ACCESS REPORT PROJECT APPLICATION

JUSTINIAN HOUSE REDEVELOPMENT

19TH OCTOBER 2007

This report has been prepared following a review of the plans to Justinian House at the above location having regard to Part D3, E3.6 and F2.4 of the BCA, referenced standards AS1428 parts 1, 2 and 4 and the accessibility provisions of North Sydney Council's DCP 2002 Sections 9.2, 20.3 and 20.4 (see attached extract).

07 422
project number
**BASEMENT LEVEL 2
FLOOR PLAN
RL.77.45**
drawing title

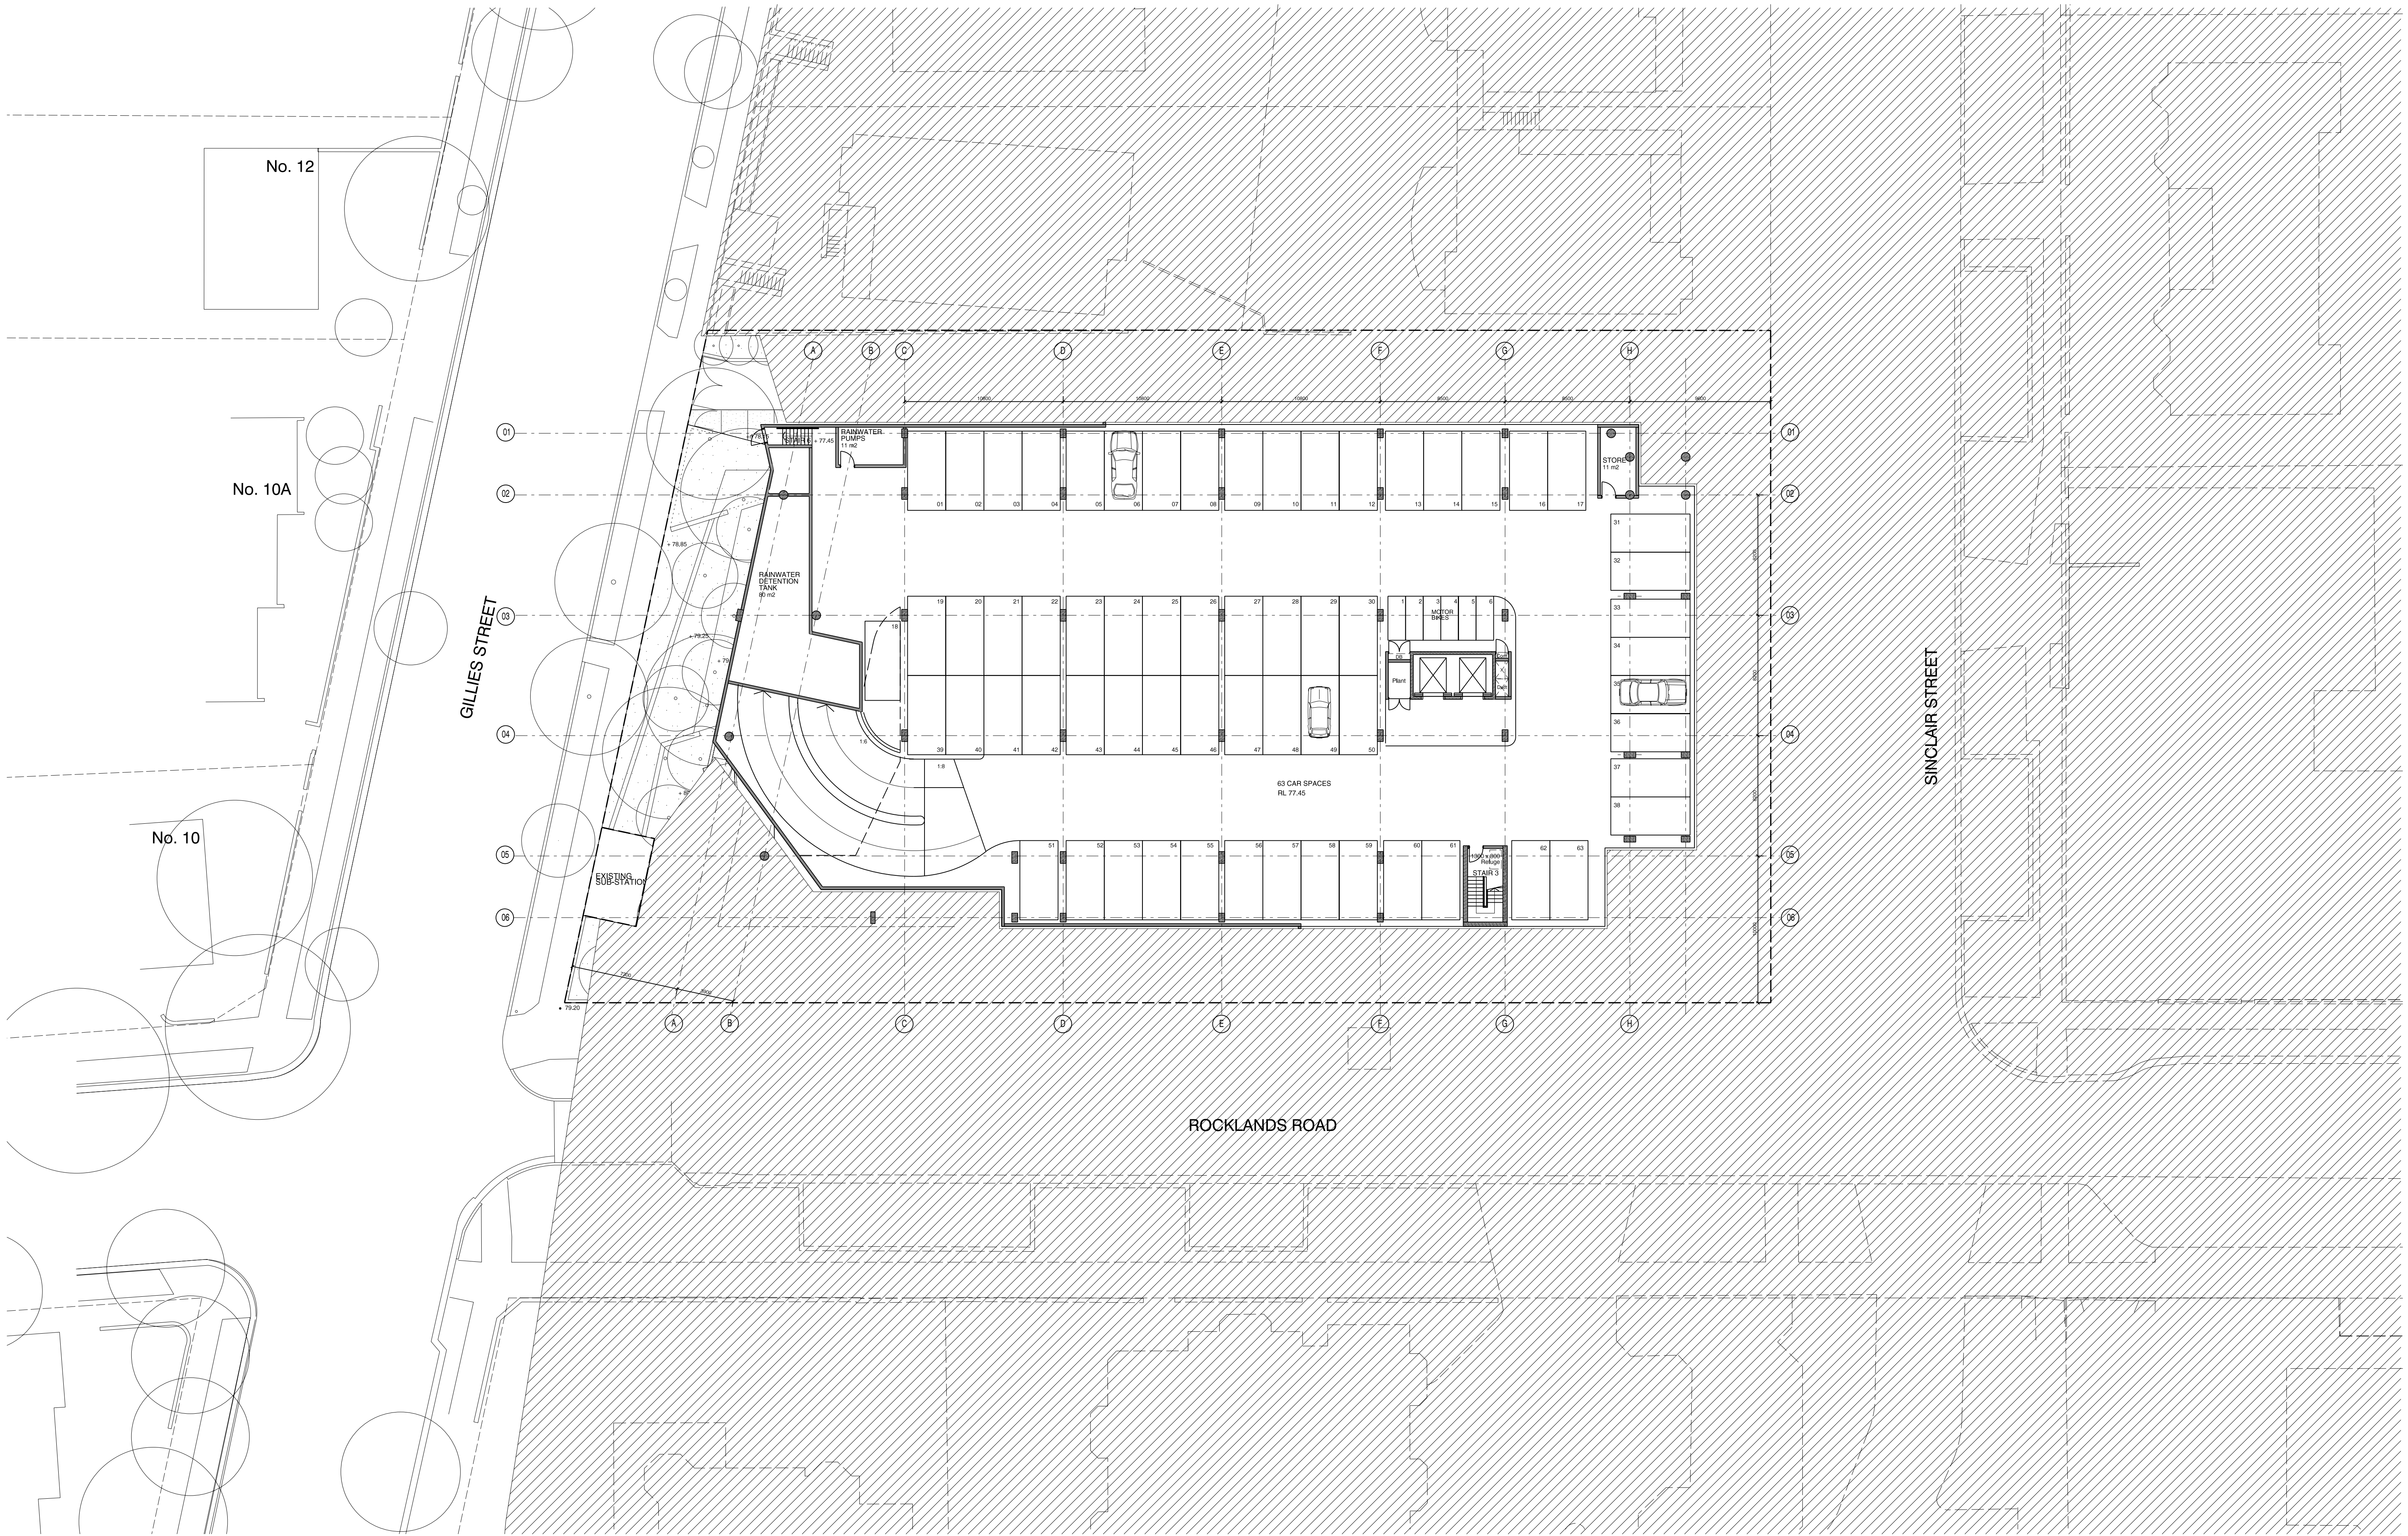
40. **Basement Level 2** – The adjoining sketch illustrates a fire/smoke isolated stairway landing on basement level 2 provides an appropriate opportunity for the provision of a 1300mm X 800mm wheelchair refuge area to satisfy this aspect of Council's DCP 2002.

**LEVEL 1
FLOOR PLAN**
RL.83.50
drawing title

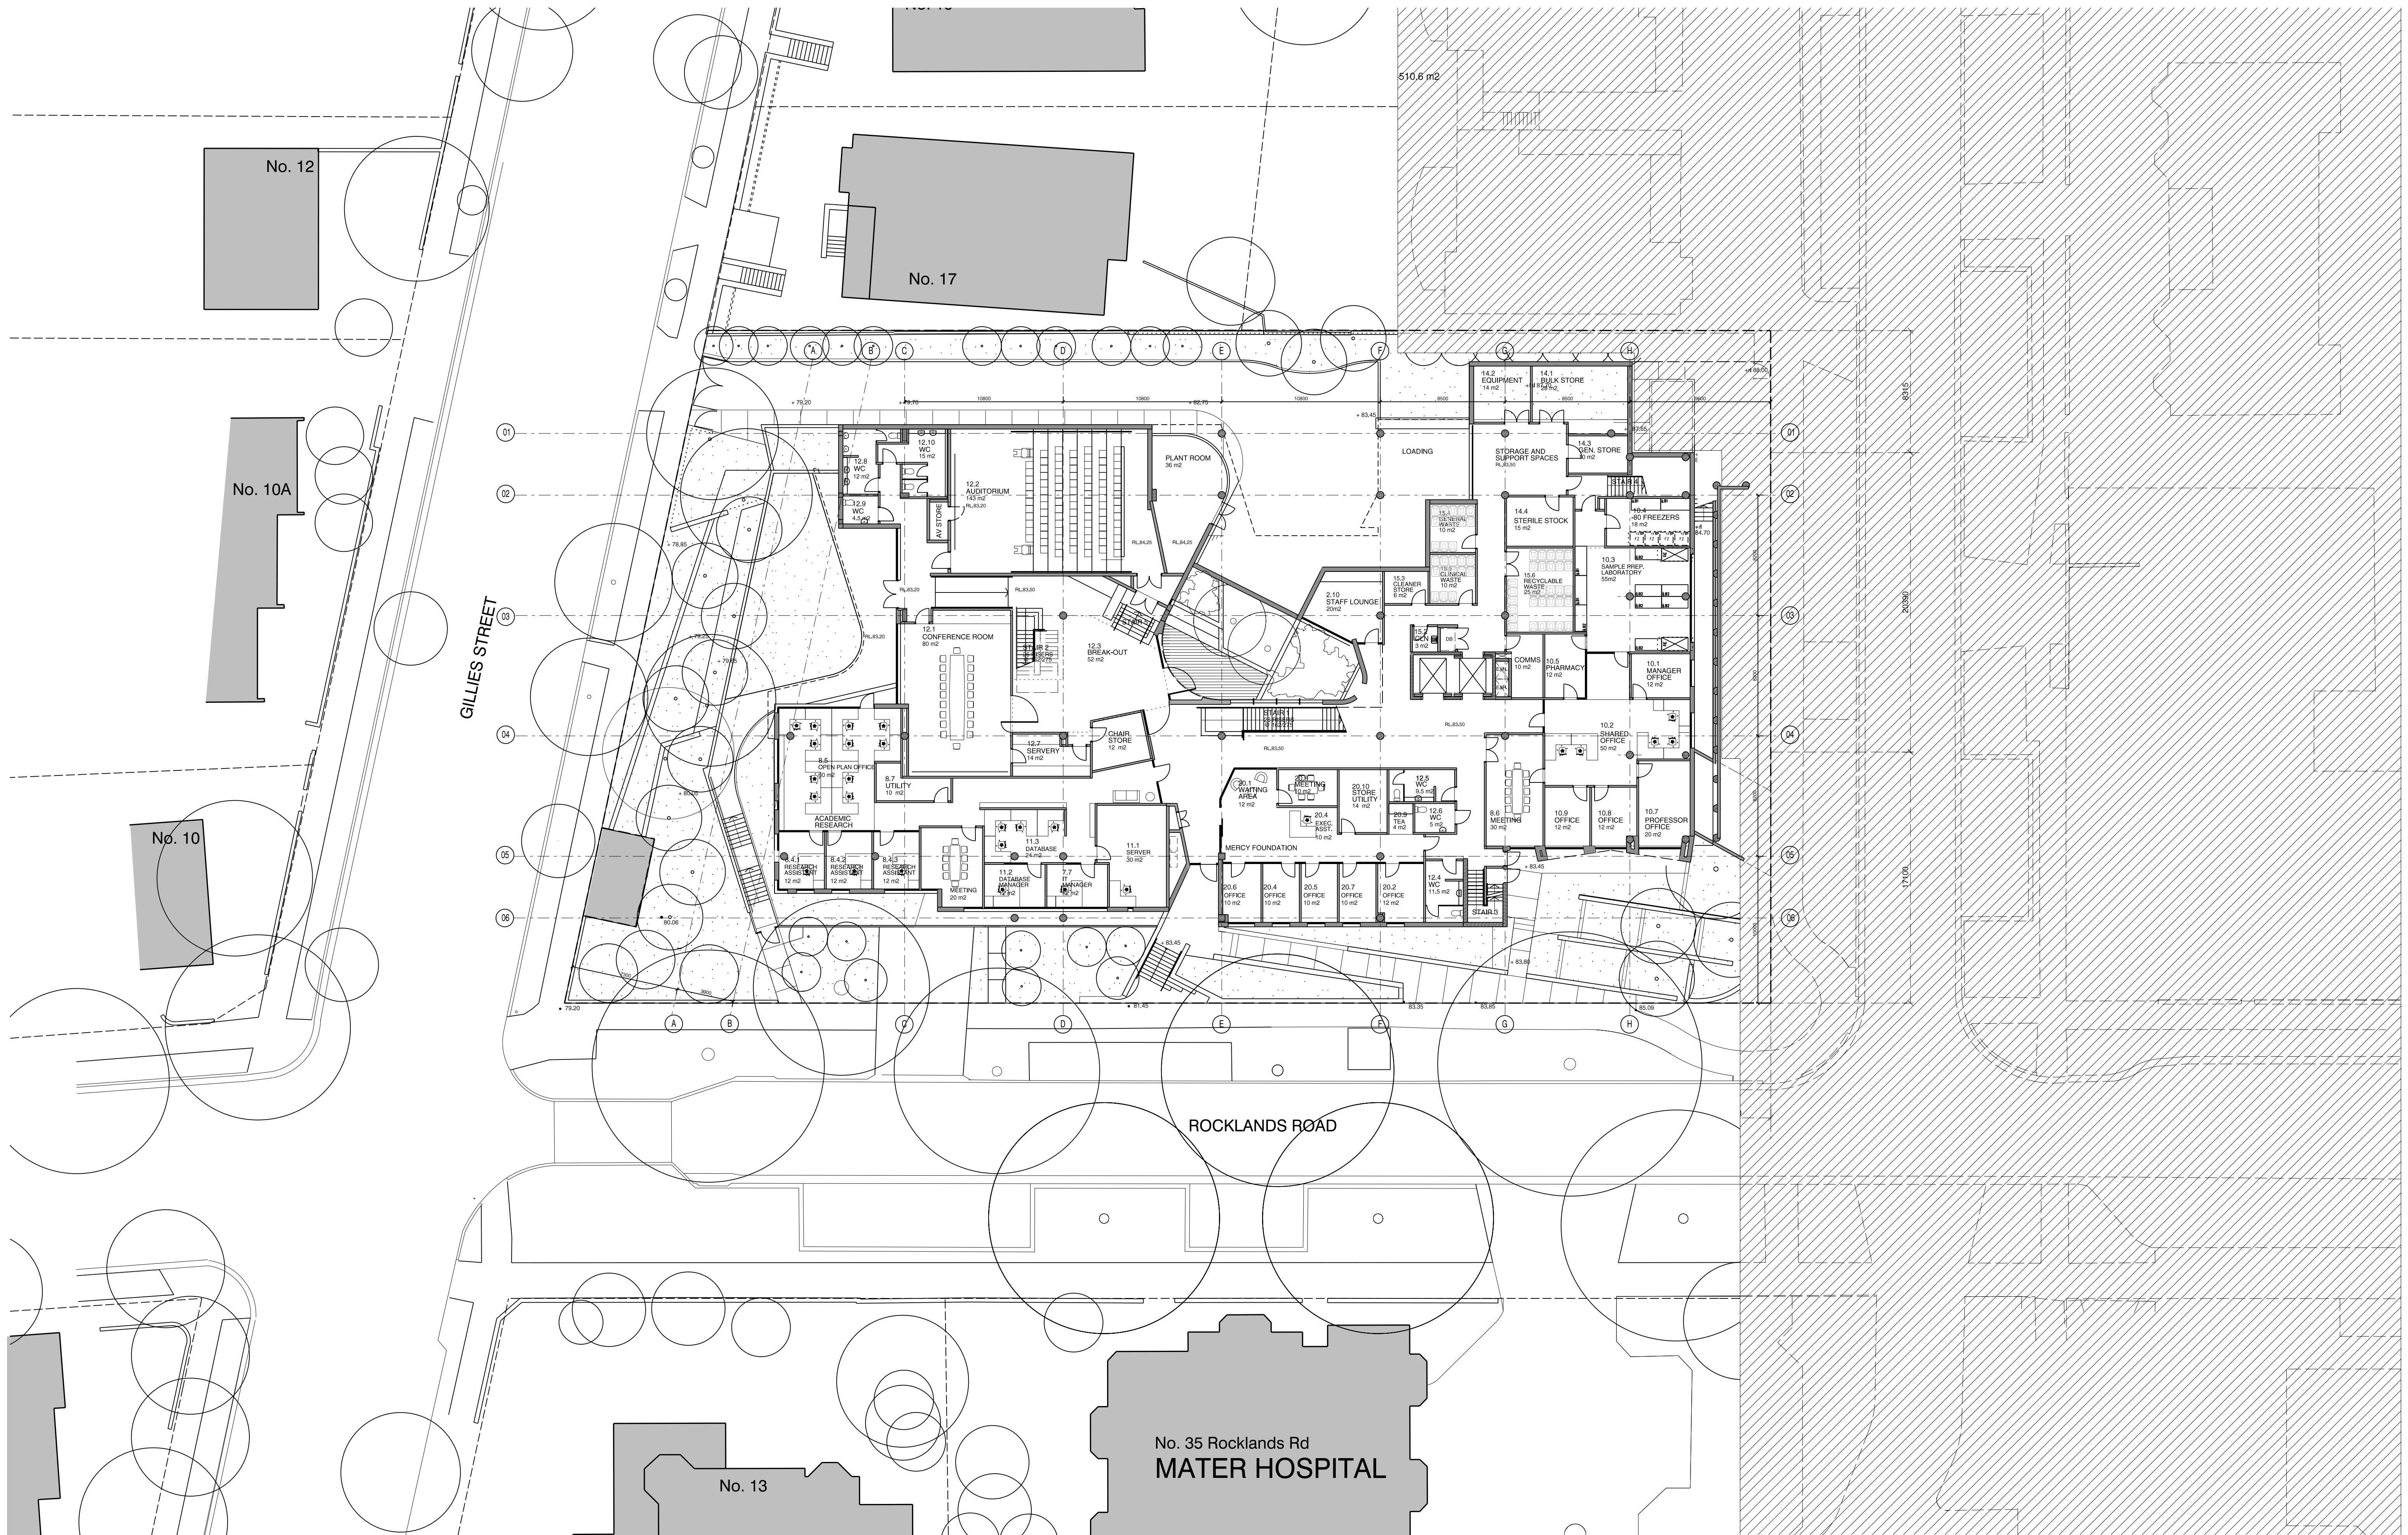
- Mercy Foundation
 - Academic Research
 - Auditorium and Conference Room
 - Administration
 - Laboratory and associated utility areas
6. **Building Entry Foyer** - With respect to accessibility the plans illustrate a building entry foyer that provides continuous accessible pathways into and throughout the ground floor areas (Level 1) required to be accessible, in a manner that will comply with AS1428.2 and Part D3.3 of the BCA subject to the comments below regarding access to individual offices and work areas.

7. **Mercy Foundation** – The reception area shall be accessible from the main building foyer and shall provide appropriate doorway circulation space to approach and enter the various offices within the Mercy Foundation in a manner that will comply with AS1428.2 and Part D3.3 of the BCA. Details of the internal fitout of the Utility Room will be confirmed at construction certificate stage to ensure adequate areas to manoeuvre a wheelchair to use a photo copier and the like in accordance with AS1428.2 and Part D3.3 of the BCA.

8. **Academic Research** - The area shall be accessible from the main building foyer via a 2000mm width corridor that will provide appropriate doorway circulation spaces to approach and enter the various offices and workstation areas in a manner that will generally comply with AS1428.2 and Part D3.3 of the BCA, with a minor adjustment to the IT Server room door, which can be detailed at construction certificate stage in accordance with AS1428.2 to satisfy Part D3.3 of the BCA. Details of the Meeting Room entry doorway will be confirmed at construction certificate stage in accordance with AS1428.1 and Part D3.3 of the BCA.

9. **Auditorium** - The auditorium proposes a tiered seated seating arrangement that will be accessible from the main building foyer/open plan breakout area via a 2000mm width ramped corridor to the lower level and the front of the auditoria. The accessible entry will provide appropriate doorway circulation spaces to approach and enter the auditoria and wheelchair accessible seating spaces in a manner that will comply with AS1428.2 and Part D3.3 of the BCA.

10. The stairway approach to the top level of the auditoria shall be detailed at construction certificate stage in accordance with AS1428.4 and Part D3.8 of the BCA regard tactile indicators.

12. Conference Room and courtyard breakout access are also readily available from the main building foyer/open plan breakout area and will provide appropriate doorway circulation spaces to approach and enter the spaces in a manner that will comply with AS1428.2 and Part D3.3 of the BCA, subject to details of the access door adjoining the foyer providing 520mm minimum latchside clearance.

13. **Administration** - The area shall be accessible from the main building foyer via a 2000mm width corridor that will provide appropriate doorway circulation spaces to approach and enter the various offices, workstation areas, staff lounge and meeting room in a manner that will generally comply with AS1428.2 and Part D3.3 of the BCA. Details of the doorways will be confirmed at construction certificate stage in accordance with AS1428.2 and Part D3.3 of the BCA.

15. **Main Stair** - The stairway adjacent to the entry foyer linking the level 1 (ground) and level 2 areas shall be detailed at construction certificate stage to include tactile indicators and handrails on both sides consistent with AS1428.1.
